Consultation Response from KC, Conservation and Design		
2021/92000 4, Grimscar Avenue, Birkby, Huddersfield, HD2 2TU		
Erection of two storey side and rear extensions, dormer windows to rear and associated alterations (within a Conservation Area)		
Date Responded: 9.7.21	Responding Officer: Sue Brooks	Responding Ref:
<p>4 Grimscar Avenue is an unlisted semi-detached house in a prominent location on the corner of Grimscar Avenue and Bleasdale Avenue and situated within the Birkby Conservation Area. The two houses were built in the mid-20th century and constructed from red brick with slate roofs, and the façades are symmetrical with arched head doorways and pairs of windows on each floor. The south gable elevation of 4 Grimscar Avenue is in line with the front elevations of the terrace on Bleasdale Avenue.</p> <p>The applicant proposes to construct a two-storey rear and side extension in brick and tiles to match the existing, with upvc windows and doors to match the existing.</p> <p>Policy 193 of the NPPF requires that when considering the impact of a proposed development on the significance of a designated heritage asset, in this case the Birkby Conservation Area, great weight shou

Roof Layout 1.50

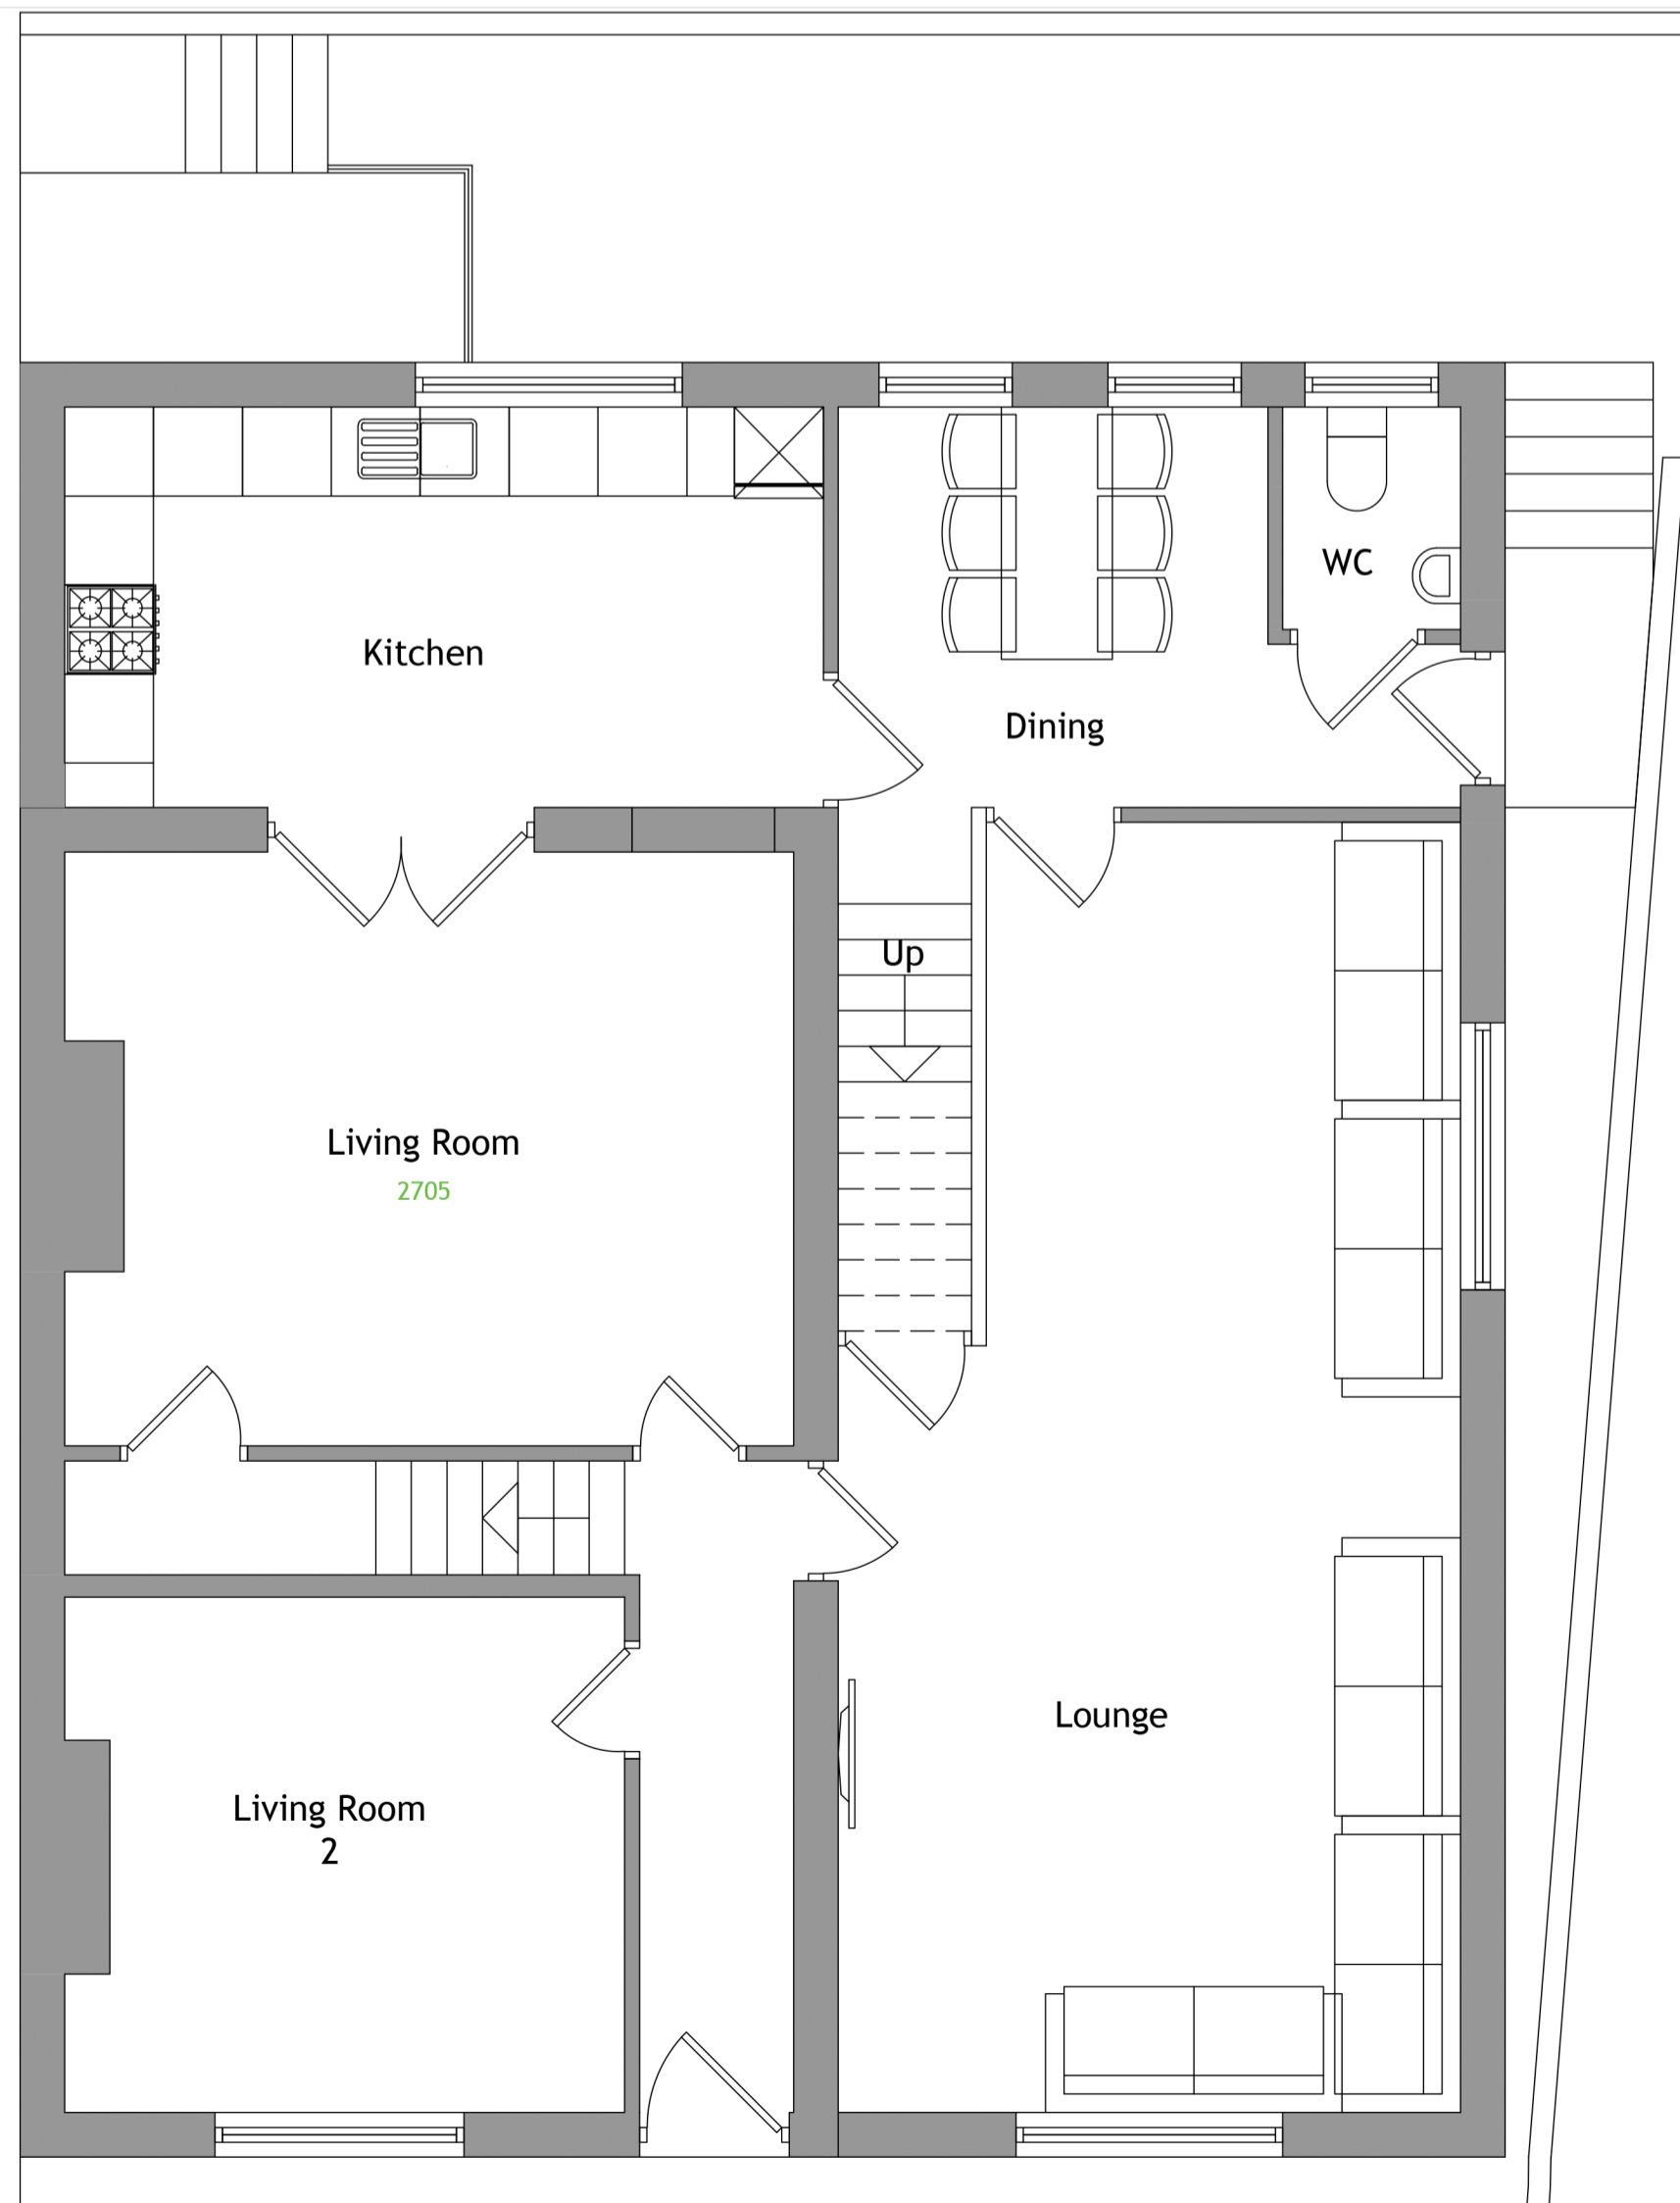
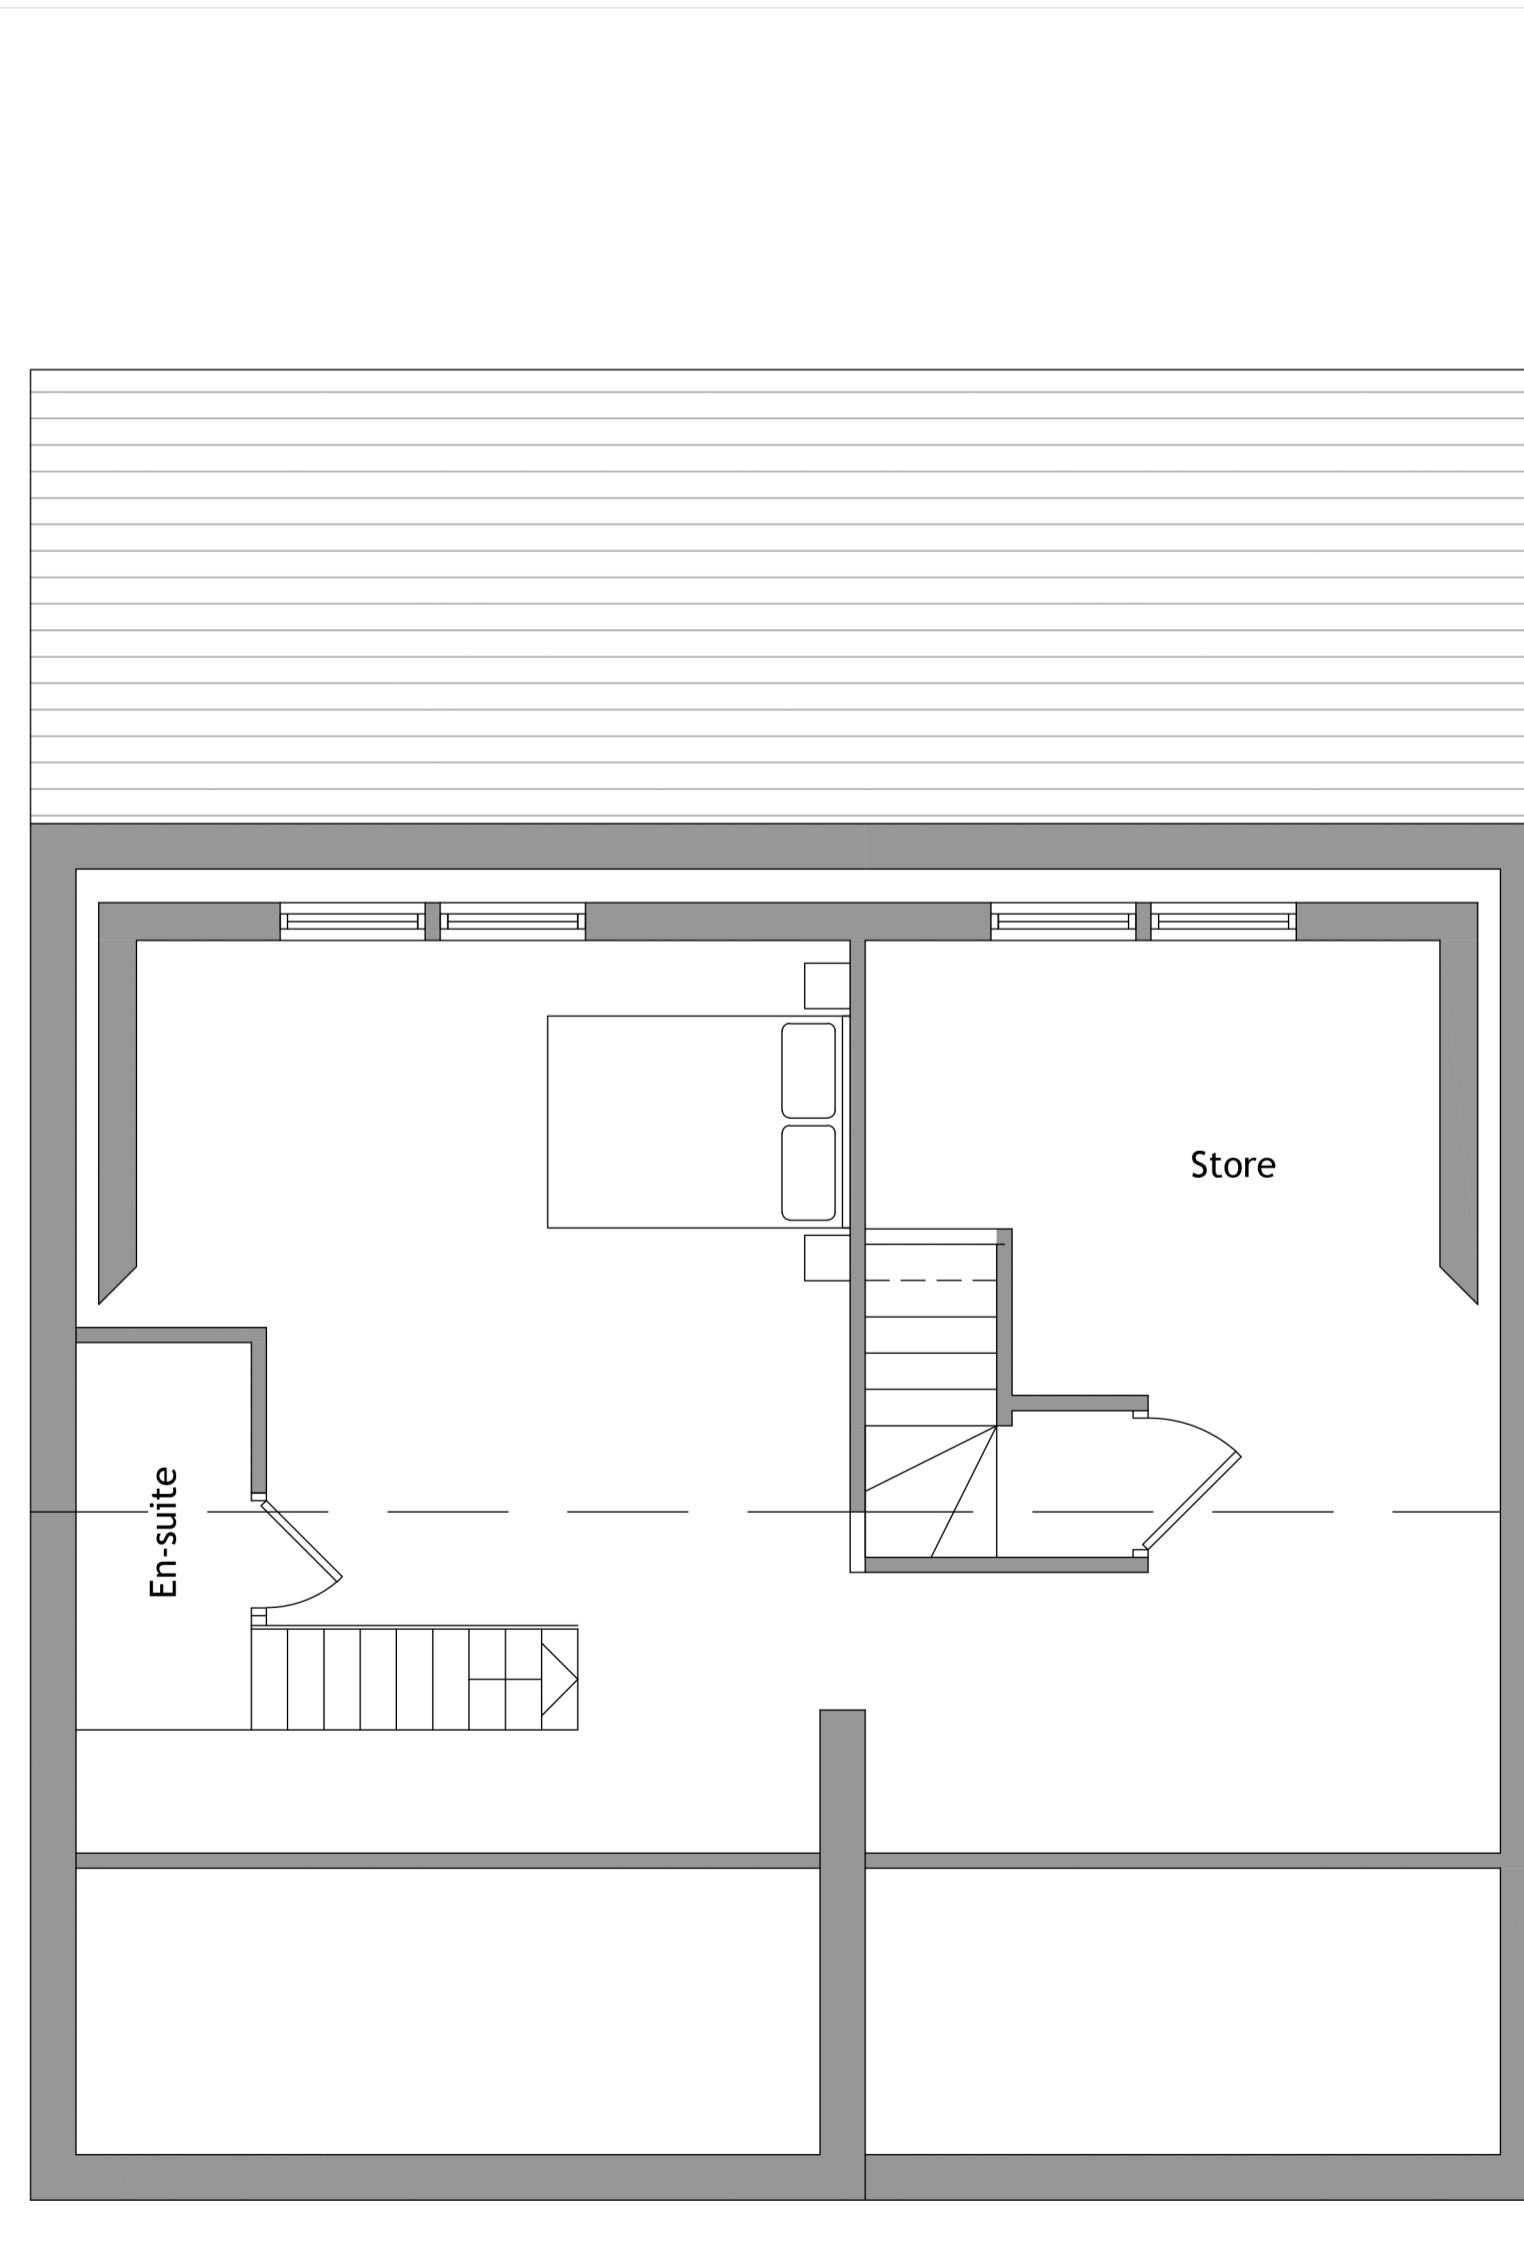
The proposed extensions and dormers do not preserve and enhance the character of the conservation area as they introduce a dominant extension with substantial dormers and a catslide roof to the rear. The scale of the extensions does not respect the surrounding character or street scene and they are overbearing.

Rear Elevation 1.100

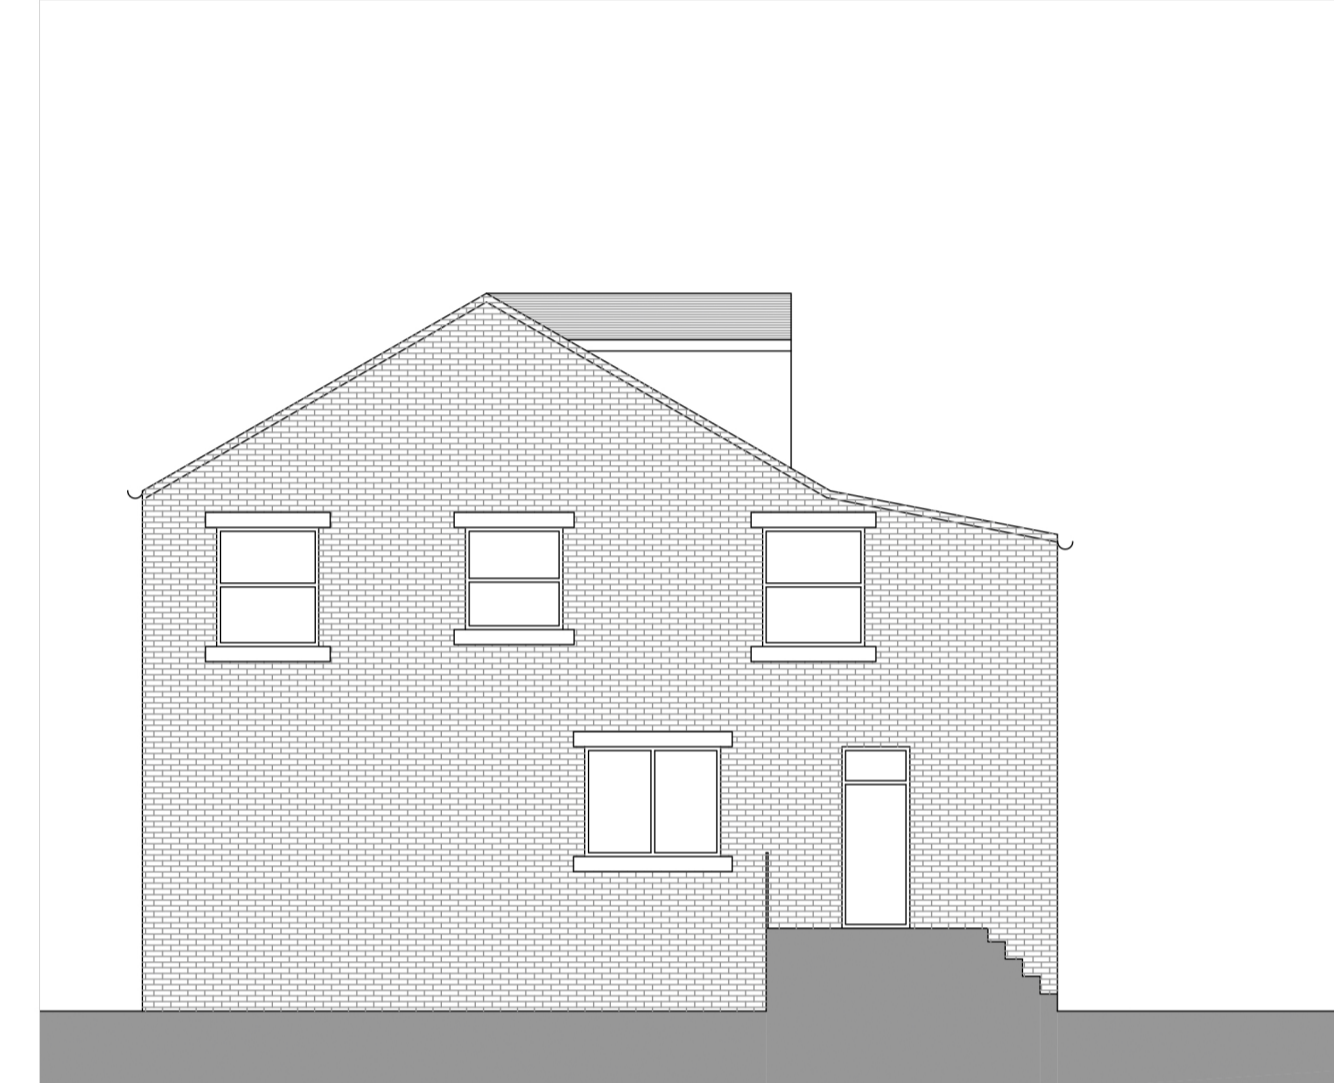
It also states that the use of red brick, to match the existing house, will allow the proposed design to blend seamlessly into the existing property, with the proposal having minimal impact on the conservation status. The use of matching red brick is not of concern, however the dominance of the extension, the change in roof pitch proposed at the rear, along with a pair of substantial dormers will detract from the character of the conservation area.
